Consultation Response from: KC Environmental Health (Pollution & Noise Control)

2024/92063 - 45a St Helen's Gate, Almondbury, Huddersfield, HD4 6SG

Conversion and extension of dwelling to form 8 apartments (within a Conservation Area)

**Responding Date:
20 August 2024**

Drg sheet 003/DP/001 A

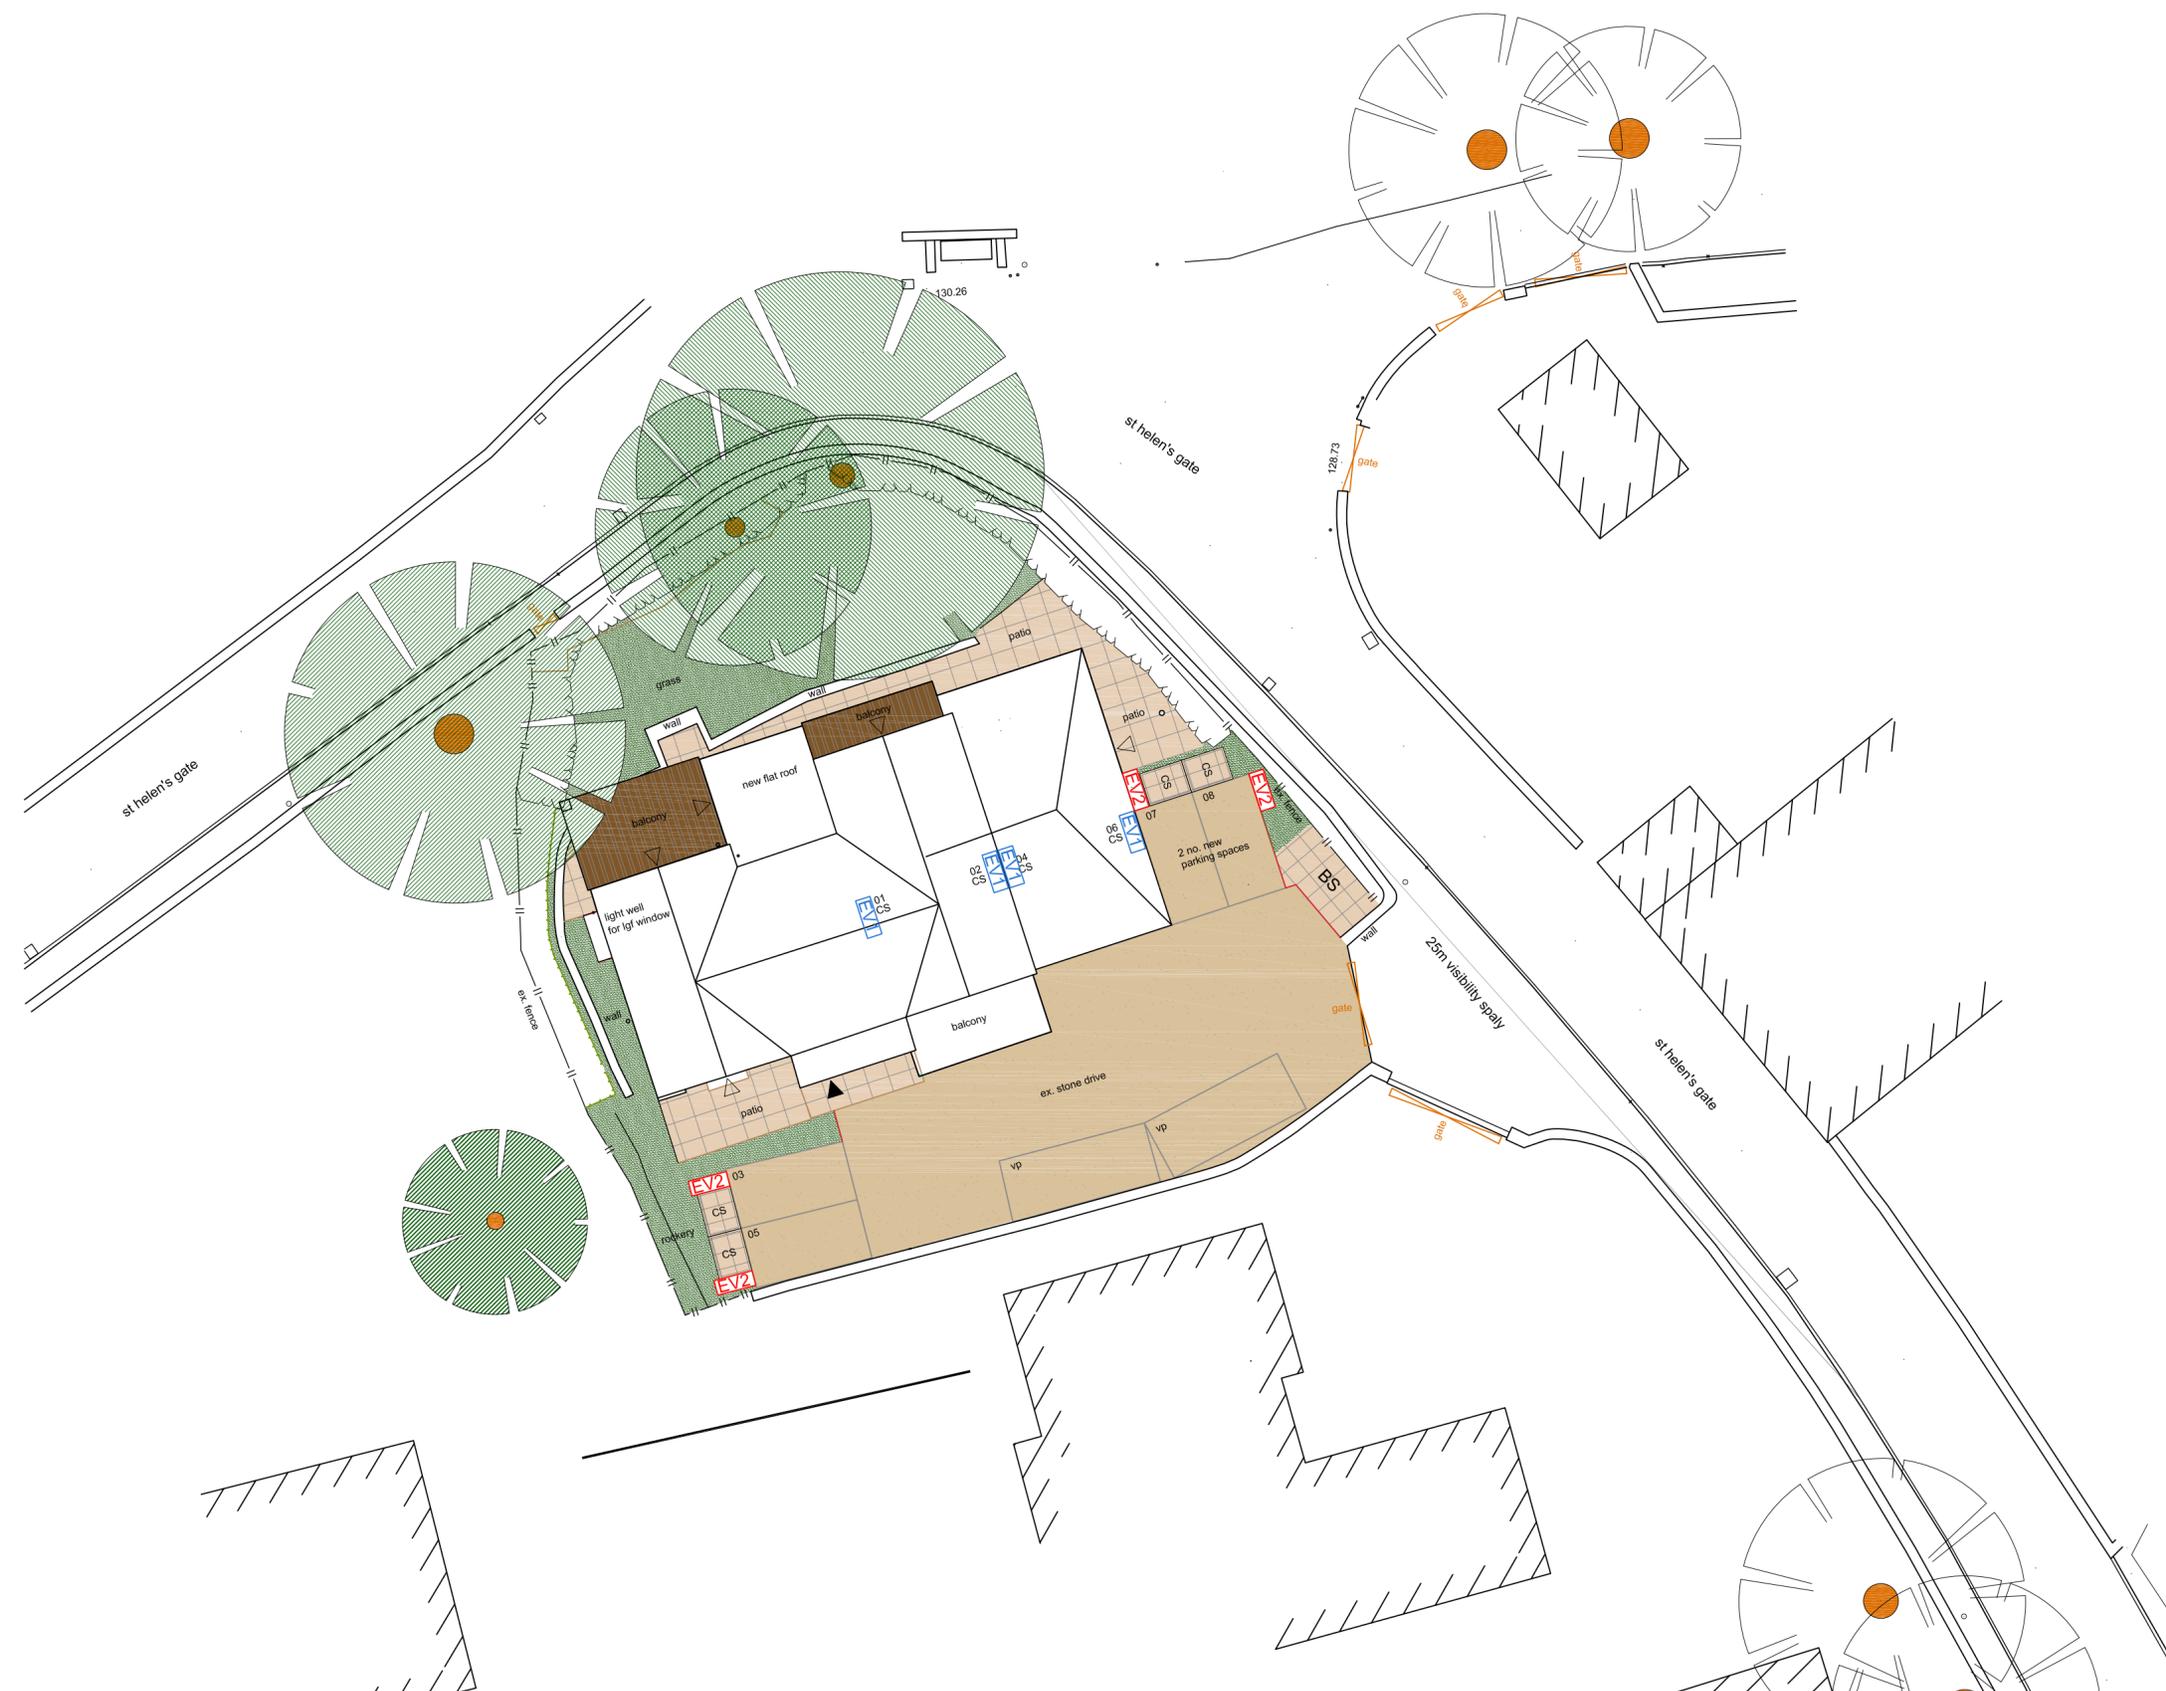
EVCPs are proposed as shown in drawing no. 003/DP/001 A. In an application of this nature, it is expected that facilities for charging electric vehicles and other ultra-low emission vehicles are provided in accordance with the National Planning Policy Framework and *Air Quality & Emissions Technical Planning Guidance* from the West Yorkshire Low Emissions Strategy Group. An advisory relating to charging points is therefore necessary.

EVF1 Electric Vehicle Charging Points – Advisory Footnote

- Approval under the Building Regulations may also be required, and the applicant should contact their Building Control Provider for further information in relation to Approved Document S.
- The electrical supply of the final installation should allow the charging equipment to operate at full rated capacity and the installation must comply with all applicable electrical requirements in force at the time of installation.
- To futureproof the development, we would encourage the applicant to provide these in accordance with the current *Air Quality & Emissions Technical Planning Guidance* from the West Yorkshire Low Emissions Strategy (WYLES) Group
